Development Control,
Arun District Council,
The Arun Civic Centre,
Maltravers Road,
Littlehampton,
West Sussex
BN17 5LF

10 February 2018

Reference: A/18/8/PL for Application for Variation of Condition 2 imposed under A/173/16/PL to read "the development to be carried out in accordance with the following approved plans ADC962/04 REVA, ADC962/13 & ADC962/14 relating to revised position of rooflights on east, north & south elevations. This application affects the Character & Appearance of the Angmering Conservation Area at Land Rear of 1 To 6 The Cottrells Angmering

A		Layout amended		10.11.17	
Rev		Description		Date	
Job Reference		Client			
New House The Cottrells Angmering, BN16 4AF		AM Homes Ltd			
Drawing Title		Drawing No		Rev	
Ground Floor Plan		ADC962/04		A	
Date	Scale	Dwg Size	Plot Style	Drawn	Checked
24.04.17	1:100	A3	ADC-red	TGS	AD

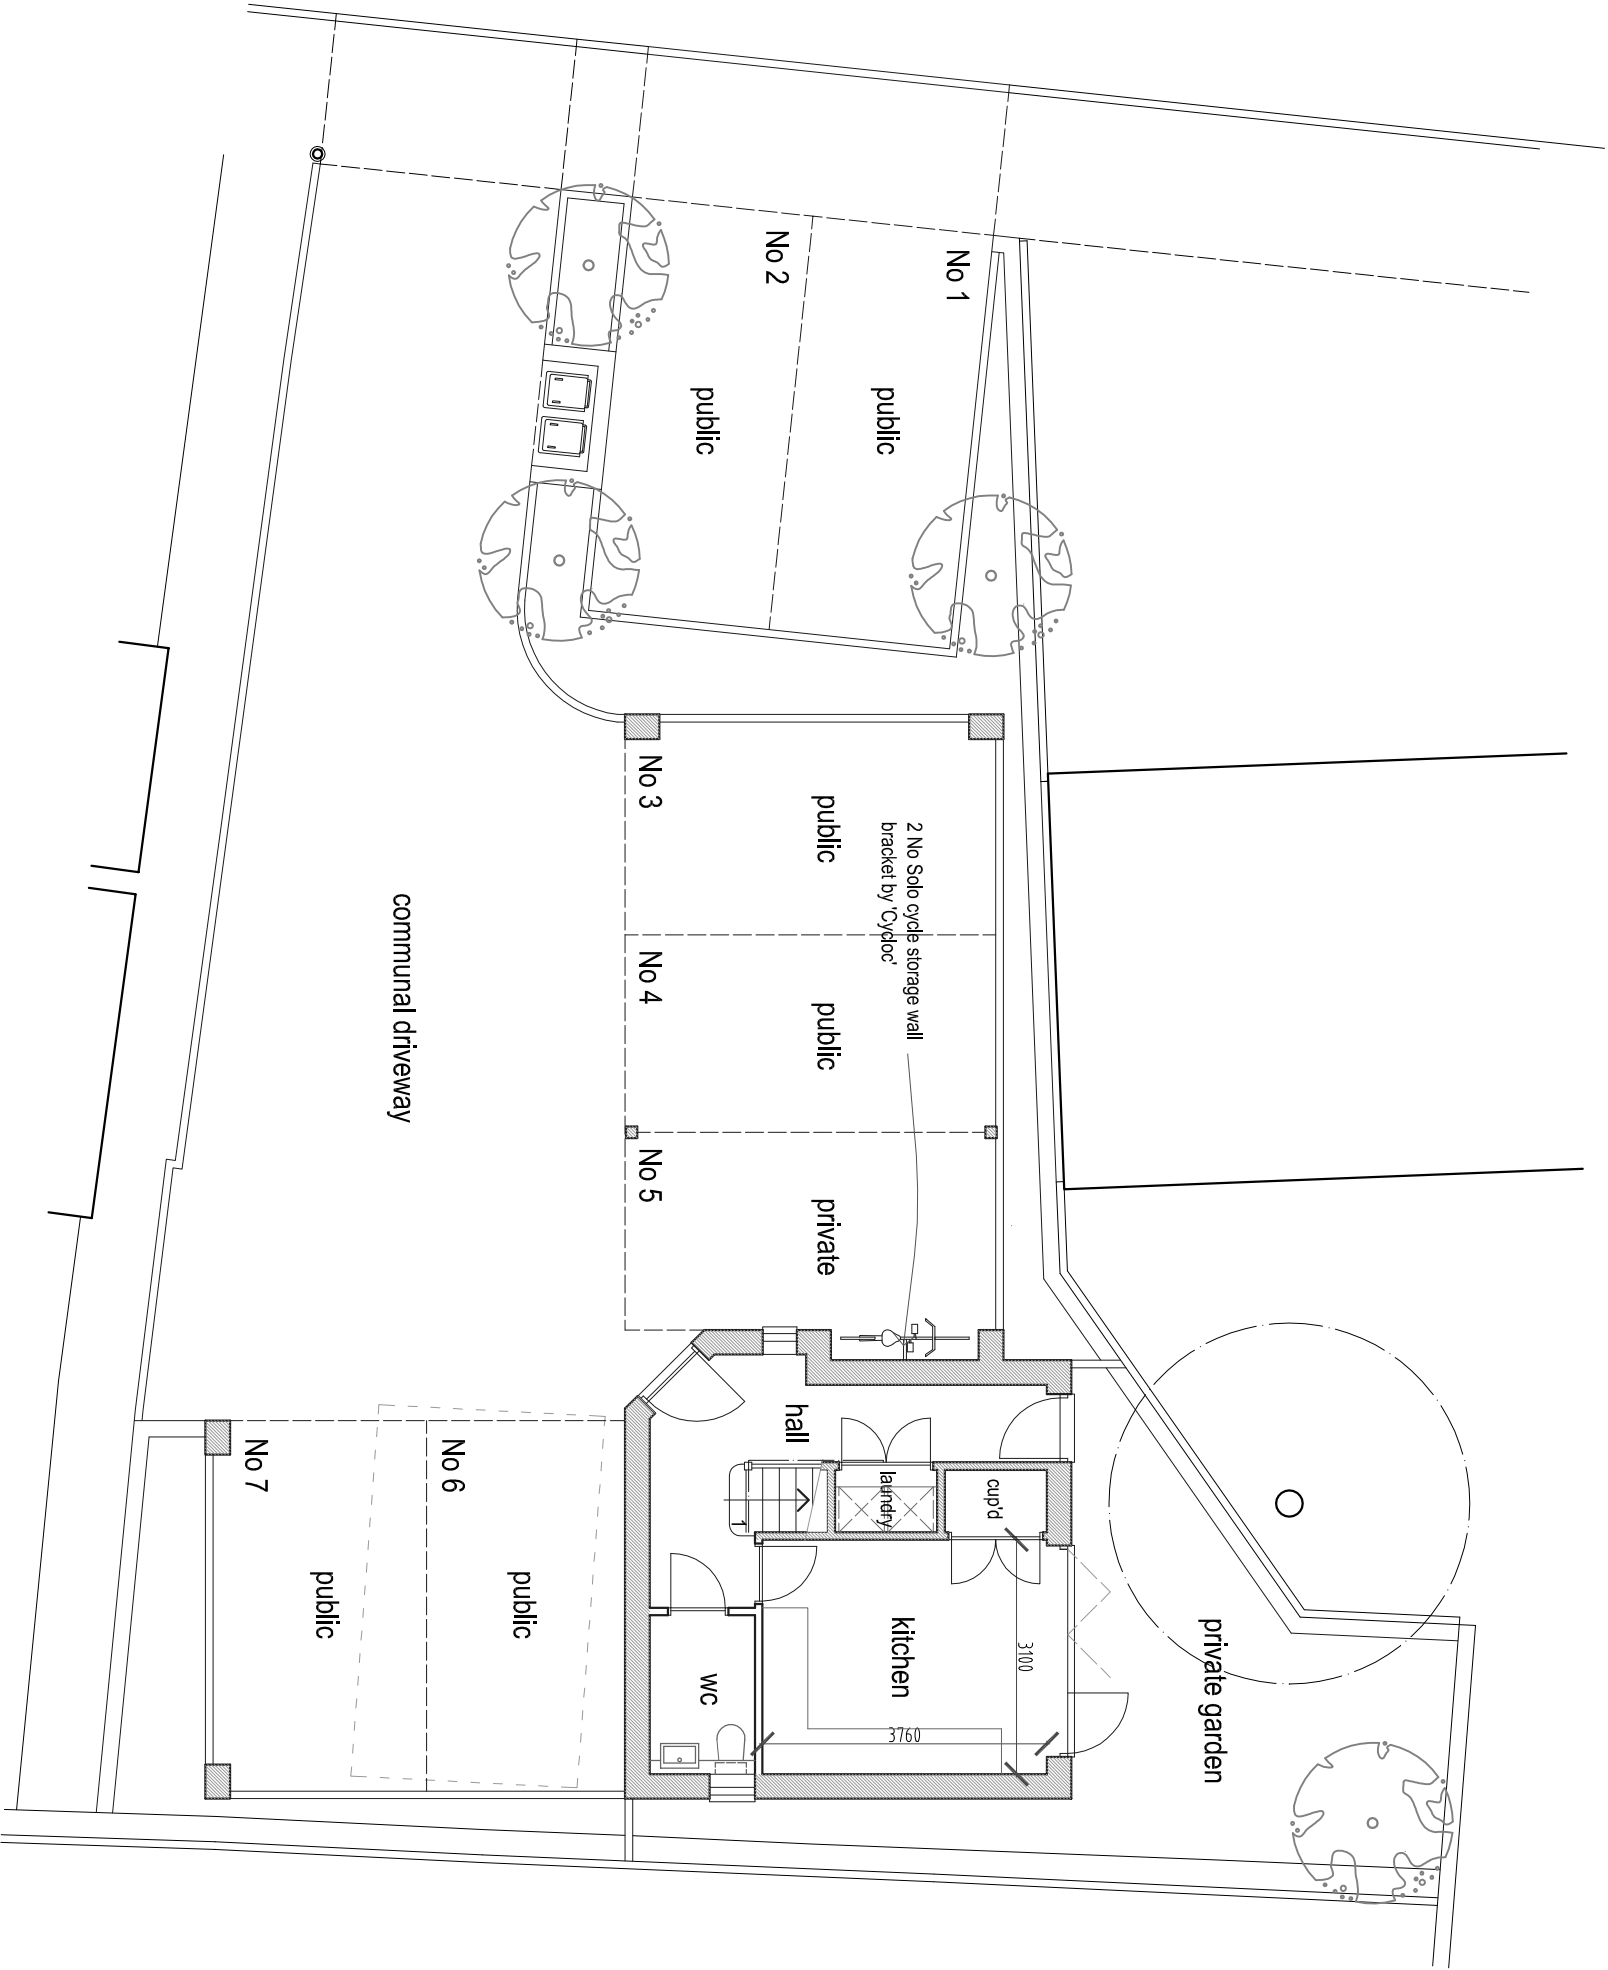
The construction has not been built to the approved plans or the submitted plans.

The image below is a scan of an A3 print of the drawing ADC962/04 REVA from which I have scaled key distances between the low block boundary wall and edges of the new building. Against these I have listed the actual distances measured by a Rackhams Chartered Surveyors who carried out a site survey on 2-3 January 2018 with the permission of A M Homes Sussex Ltd.

You can see that the building has been built incredibly close to the boundary. It is now impossible for us to maintain our timber framed garage from our land. It also adds to the visual overpowering impact of the new building when viewed from our garden.

I appreciate that ADC must provide some leeway for siting but this should be centimetres not metres for a building this size. Any distance greater than 25cm is surely an example of incompetence or a deliberate action.

We instructed the surveyor to only measure the elements close to our boundary. I request ADC obtain an accurate set of detailed building plans, establish if they match the approved and submitted plans and carry out a visit to verify my measurements and also establish if the building has been built bigger overall.

I request that these parts of the building on the northern elevation that have been built incorrectly are demolished and rebuilt according to the plans.

The rejected plans A/162/16/PL identified the kitchen upstairs and a Bedroom 3 downstairs. The submitted plan matches the original two bedroom layout with the kitchen upstairs but the building has been built with a new internal corridor and access door next to the french windows (see image below). This is very appropriate if a Bedroom 3 is downstairs.

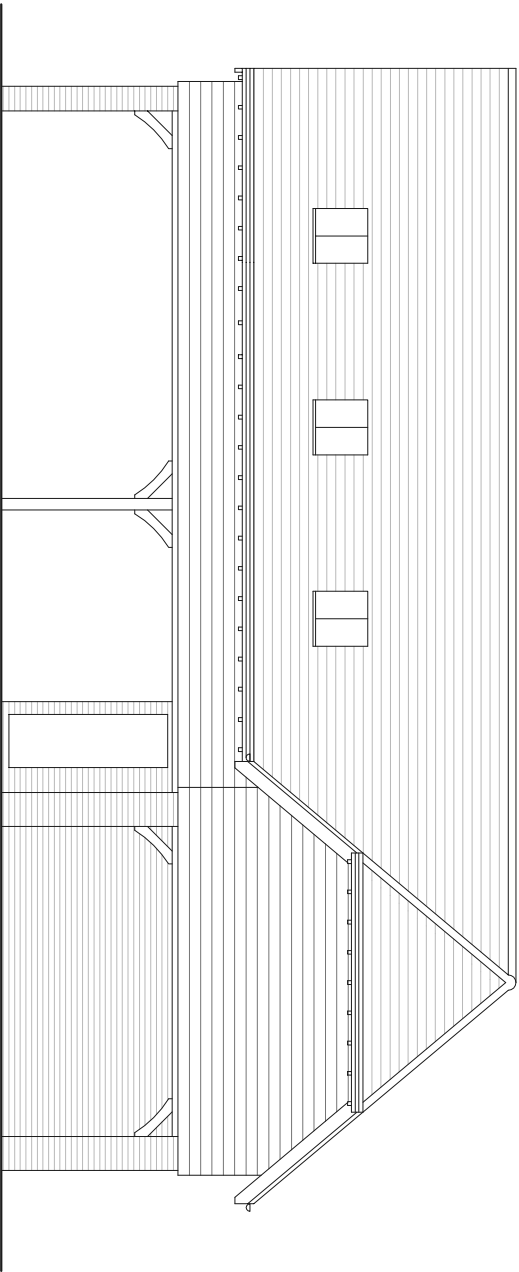
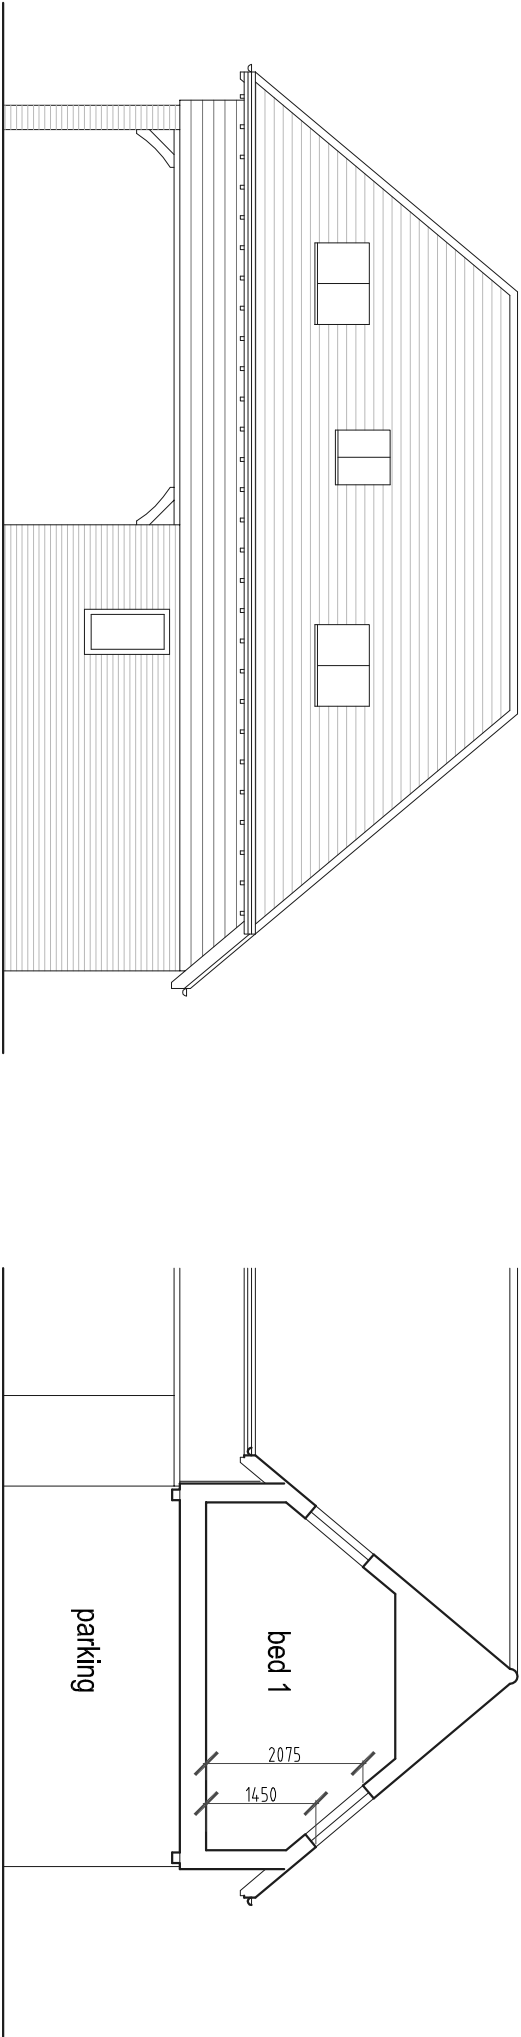
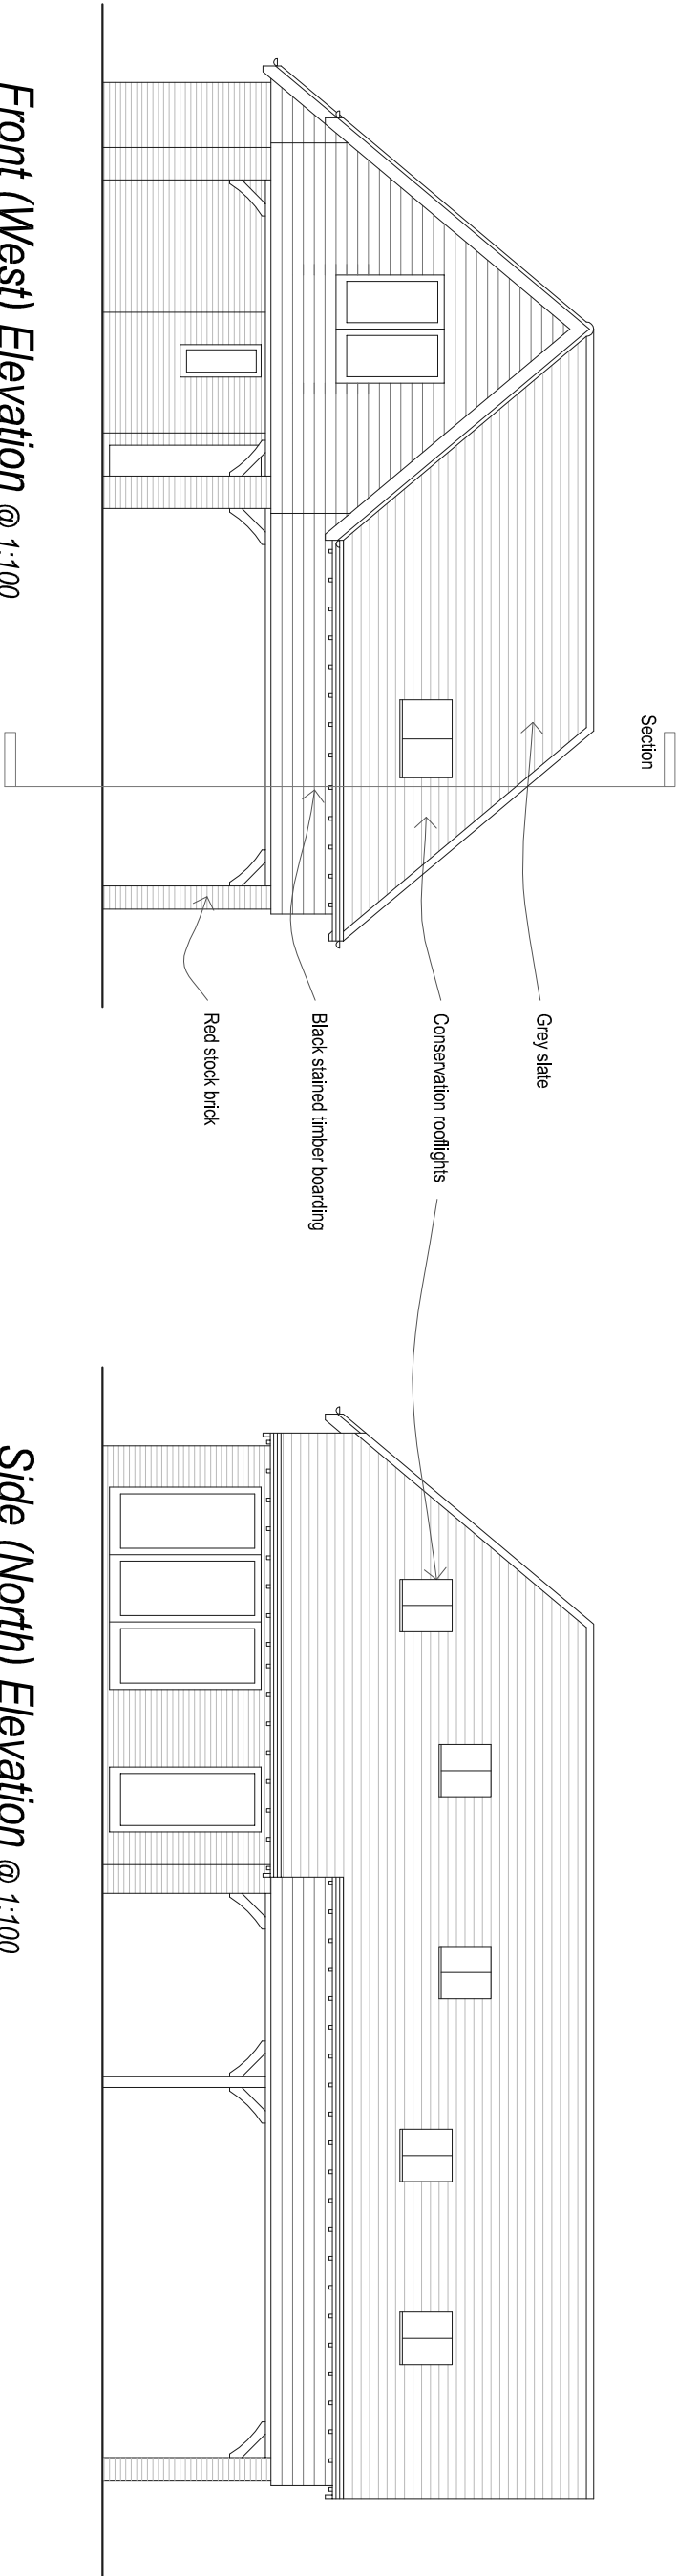
Alongside is an image from the submitted ADC962/14. The rooflights that have been installed are described as "Conservation rooflights". When viewed from the ground, they appear to be standard Velux windows and we have seen that they can be easily opened (by the builders during construction). This has improved the quality of the building materially and reduced the privacy for the neighbours.

I request that the installed openable Conservation rooflights are removed and replaced with Escape roof-lights as in the approved plans.

The image below is from drawing ADC962/14. The distance of the installed window shown is 1.45m and the application is seeking permission for this, a full 0.25m lower than the guideline.

I request that ADC measure the other windows to ensure they have been built to 1.50m and reject this application for those built to 1.45m.

The view from Bedroom 1 overlooks our property and has approval for a rooflight with the bottom edge 1.5m from the floor. As I write this, sitting in our kitchen, I have a direct line of site to this window. **I request that the glass in this rooflight be frosted to preserve the privacy of us and the occupants.**
